Our Ref: SW22-123-L01

RE: SW 22-123 – NEW DWELLING, ADJ 22 STATION ROAD, GEDNEY HILL (Ref H07-0089-22)

Further to your correspondence dated 04th February 2022, your ref 22_06054_P, please see our responses to your queries below.

Soak-Away Test SA 01

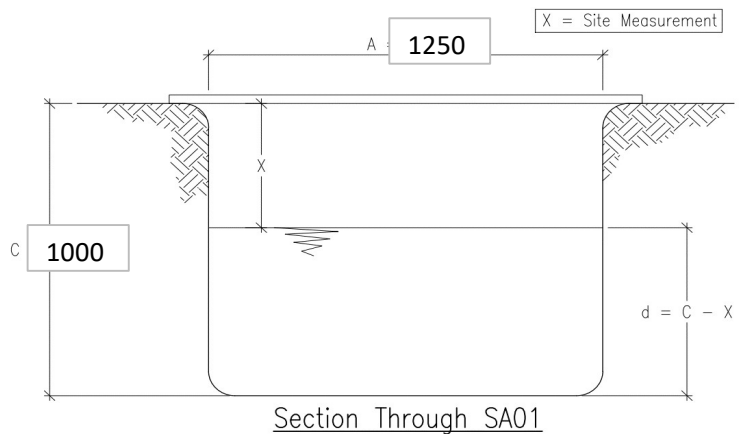
As we are sure you are aware, infiltration testing in flat low-lying fenland areas very often takes a considerable amount of time to complete. Therefore, it is rarely possible to expect test fills to empty during the course of a single day and unrealistic to expect 3 test fills to be completed. This being the case test fills would need to be undertaken on 3 consecutive days.

Infiltration testing was undertaken generally in accordance with the guidance set out with BRE 365.

Test pits were refilled, and two tests were obtained from the same pit.

For a small single plot development site such as this, it is unfeasible/uneconomical for field testing to be carried out over a 3 day period of time. We would note that historically the practice of completing one test fill measured over the whole day, or two test fills measured for half a day each has always been accepted in this area as appropriate.
